I would like to comment on planning application 2024/93114

This planning application relates to my immediate neighbour at number 17, I live in the property furthest from the road on the plan supplied at the end of the shared drive. I have a third party boundary with Mr McClure, as the property line runs alongside the garage which the applicant is looking to demolish and I and my property will be directly impacted by the suggested development. Mr McClure has at no time discussed any plans for this extension or how it will impact the third party boundary or his neighbours. My concerns around the suggested development are -

Proposed Site Layout
Scale 1:500

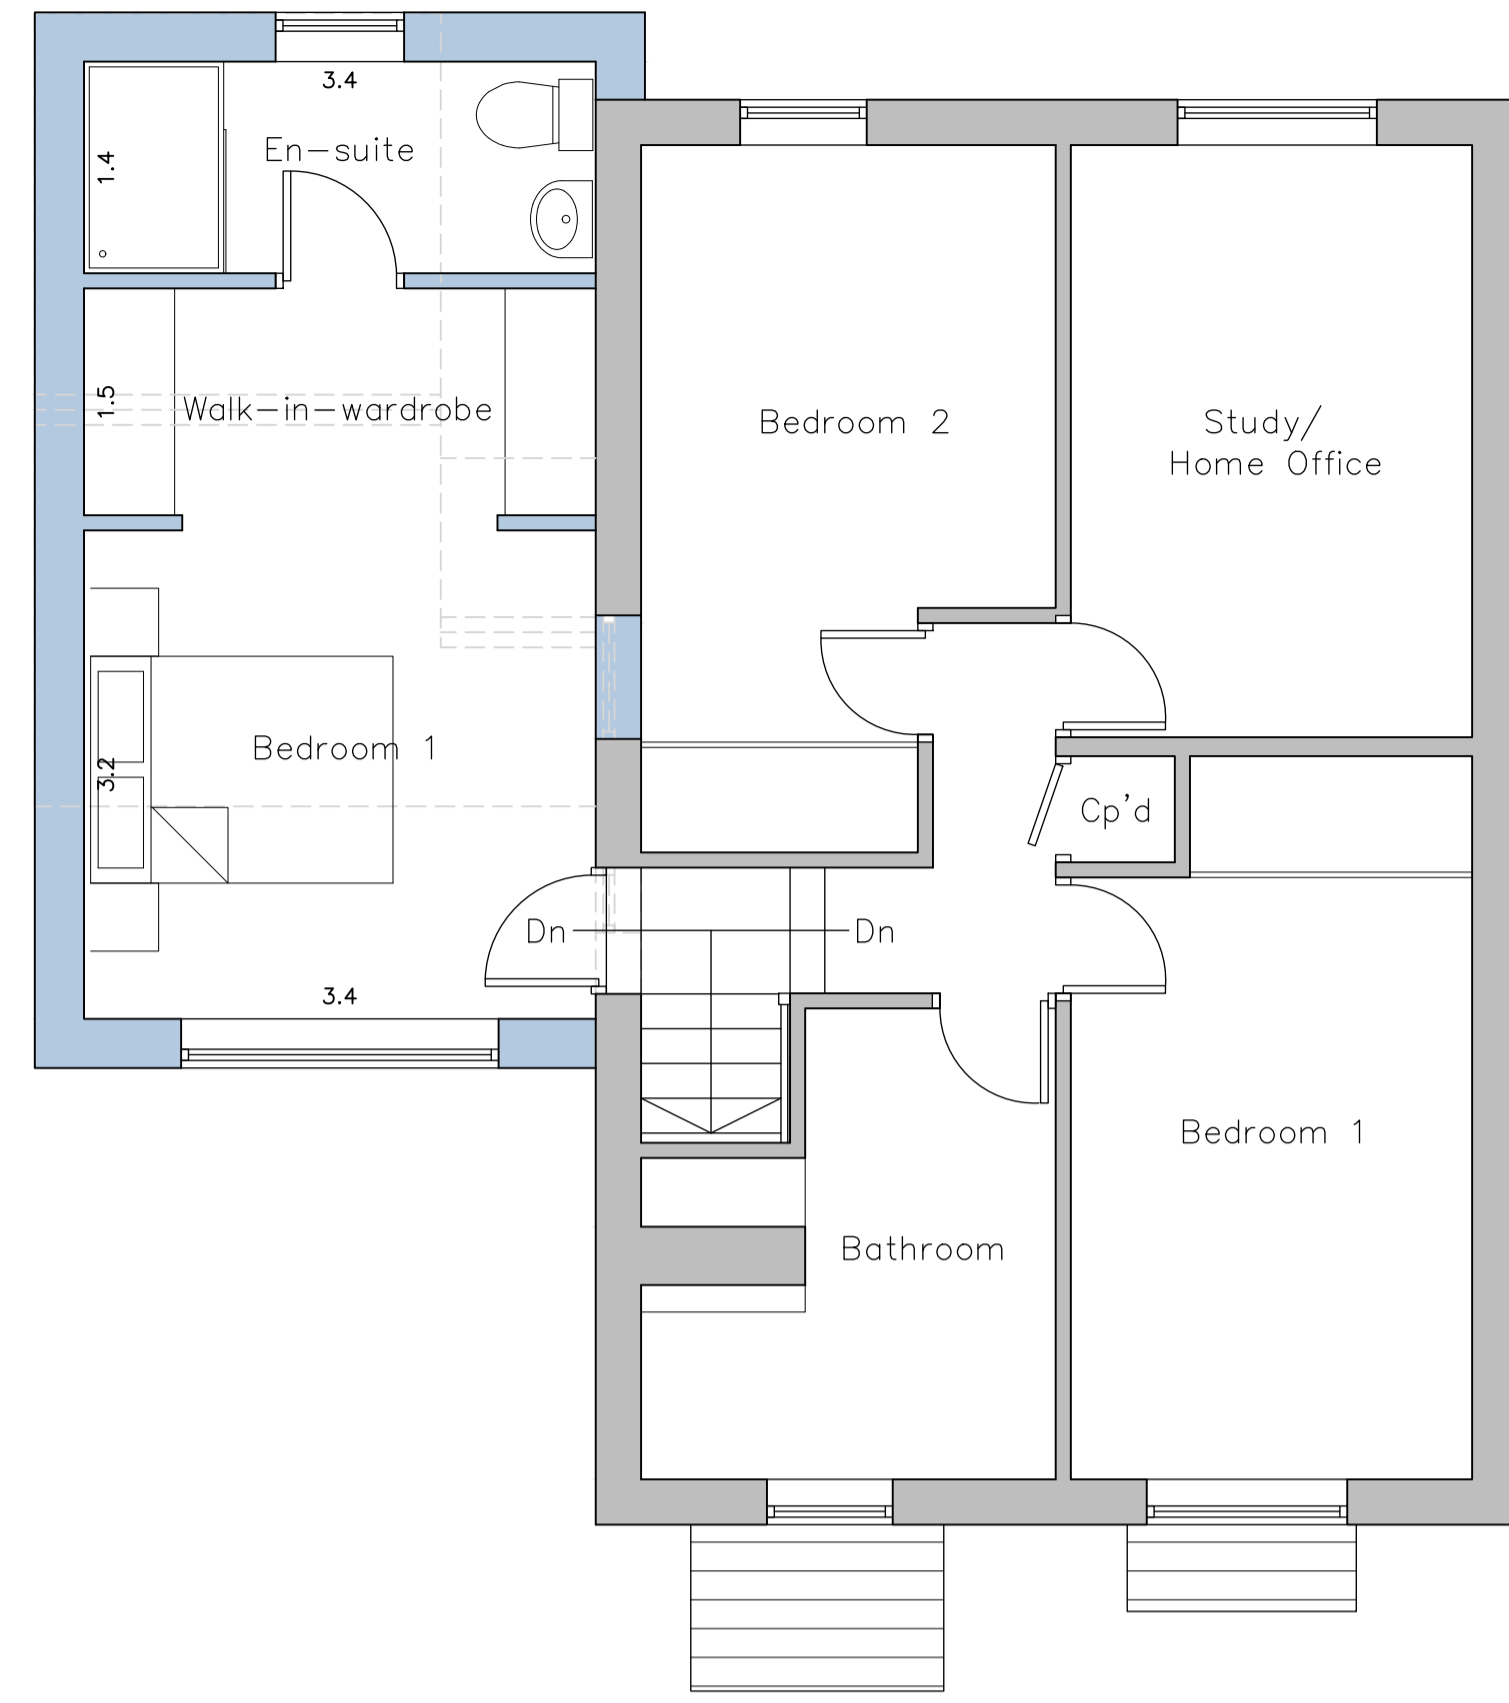
1. There are three houses in our corner of the Durker Roods estate which share the same drive, of which number 21 is the middle property. I am concerned the plans submitted, seem to show a generous amount of land at the front of our properties, most of the land to the front of our houses is on a steep slope into the back gardens of properties on Mill Bank Road and not useable for anything other than garden. The houses have access along a narrow drive from Damley Close which is approximately the width of a single drive with very little room for manoeuvring once on the drive. No suggestion has been made that the drive is to be widened to give better access to the properties at any point. I have attached a photograph showing a view of the drive, with Mr McClure's car in its normal parking position at number 21.

3. Along the front of my property runs a footpath, see photo attached, this is original to the building of the house at No 19 and joins my porch to the drive of number 21 at the corner of their garage. Access to this path is protected under the right of access. It is the only flat access to my property, as I have a steep front garden and moving the frontage of the garage forward by 1.2m will completely block the footpath and leave me with no flat access to my home.

4. I note on the application, Mr McClure appears to be looking to establish a third parking space, with the outline of a vehicle shown parked at a 90 degree angle to the front of his property, hard up on the property line with number 23. His front garden is a lawned semi circle and would not allow sufficient space for a vehicle to park in this manner without parking in the right of way. It would block access rights and make manoeuvring around the drive difficult if not impossible for all three houses. If a third parking place is essential, there maybe sufficient room to establish a space parking horizontally to the house, on what is currently the front lawn, but would have to be contained fully within this area.

Proposed North West Facing Rear Elevation
Scale 1:50

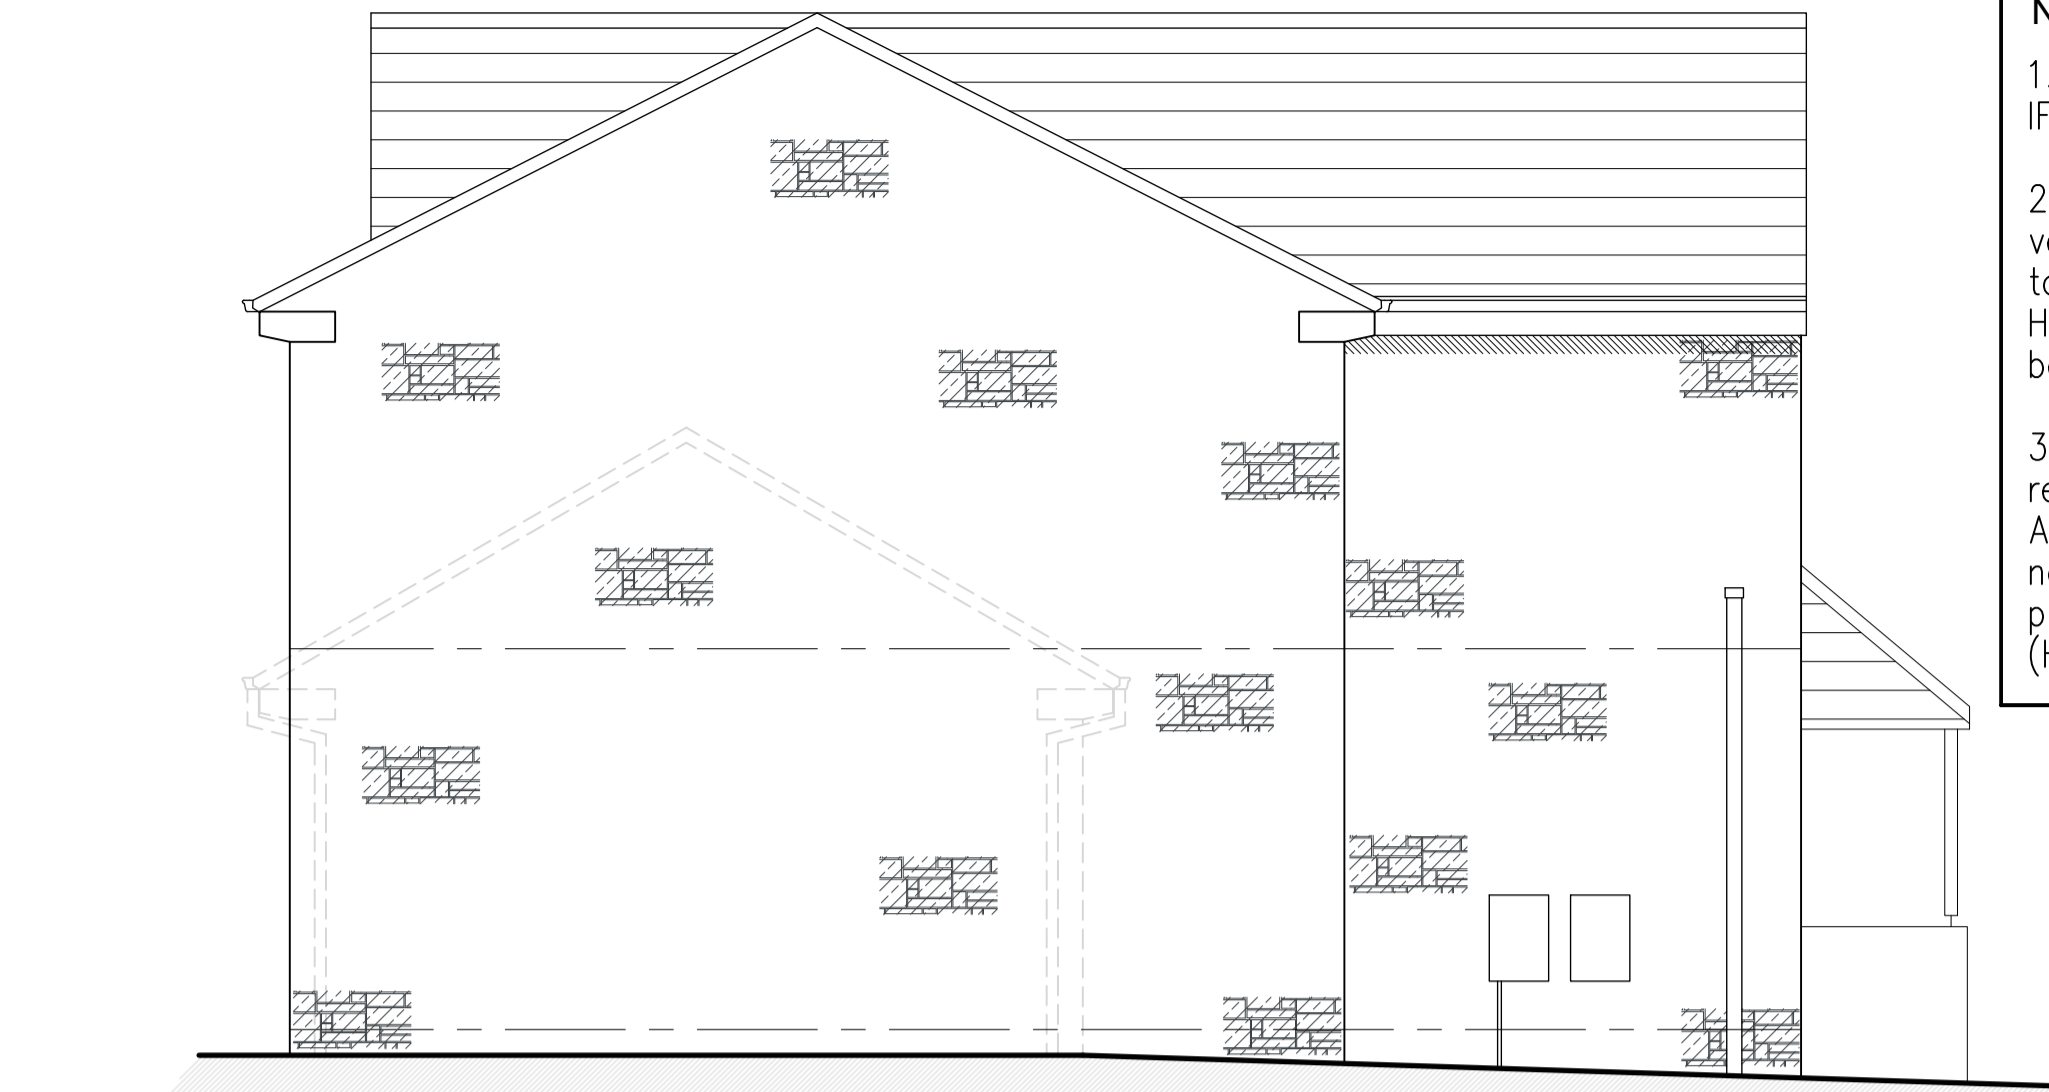
6. By building up the garage to a second storey, there will be a bathroom window directly over my back garden fence, this will over look the whole of my rear garden and into my conservatory and intrude on the privacy of my property.
